Heritage Council

RE: STATE SIGNIFICANT INFRASTRUCTURE – NORTH WEST RAIL LINK (SSI- 5414) - REQUEST FOR COMMENT ON ENVIRONMENTAL IMPACT STATEMENT

Section 11 of the EIS (dated October 2012) and Technical Paper 4 (dated March 2012) specifically deal with European Cultural Heritage issues.

Figure 5.4 North West Rail Link Construction Site 4—Cherrybrook Station, showing impact zone and area of archaeological potential.

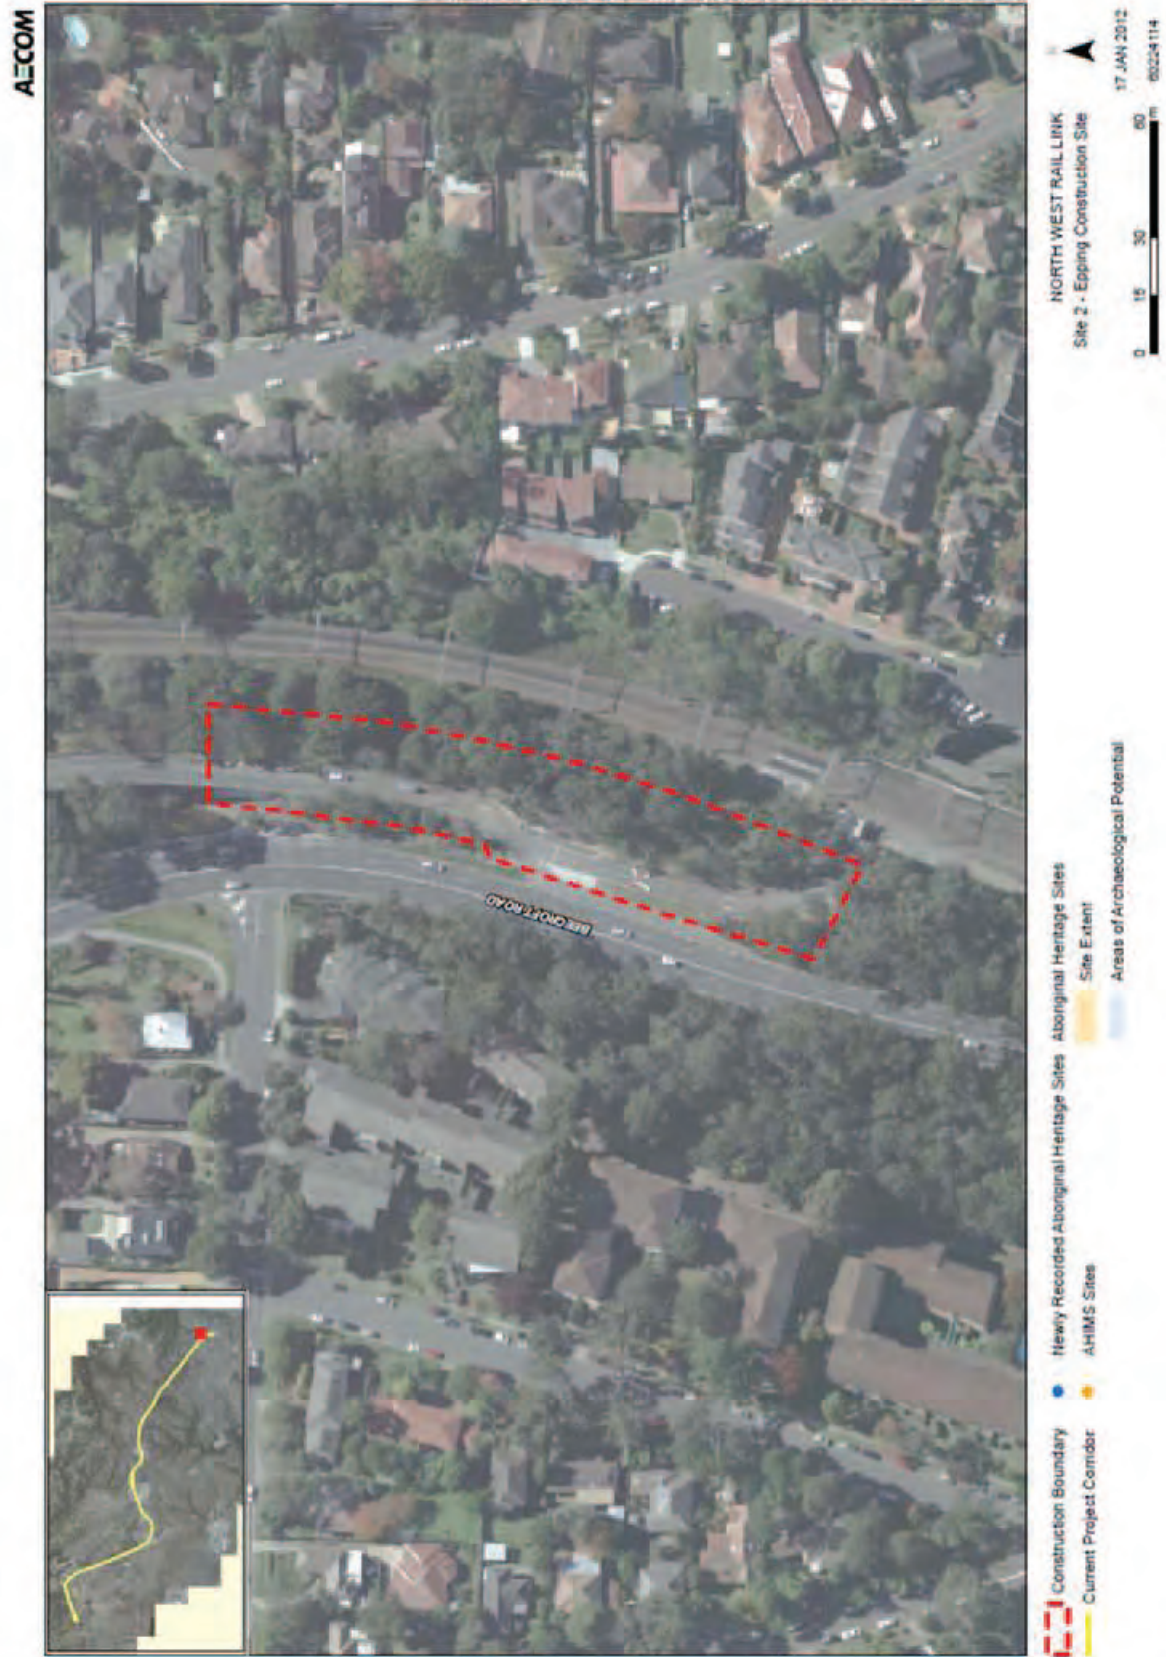
Cherrybrook Station (4) – Archaeology on Franklin Road

Page 71 of the EHR states that in order to determine any required mitigation this site requires further assessment/research to determine its archaeological potential/significance as there will be a *moderate adverse impact*. Page 11-6 of the EIS states that *no impact on archaeological remains is anticipated*. This is the complete opposite conclusion to that identified in the EHR with no reasons given as to how this conclusion has been reached. It does not appear that the further archaeological research recommended has been undertaken.

3. A condition of consent should be included to ensure that all the further archaeological assessments recommended in the EHR are undertaken. An additional condition should be included to state that the results of these assessments and identified mitigation must be assessed and endorsed by the Department prior to construction commencing.
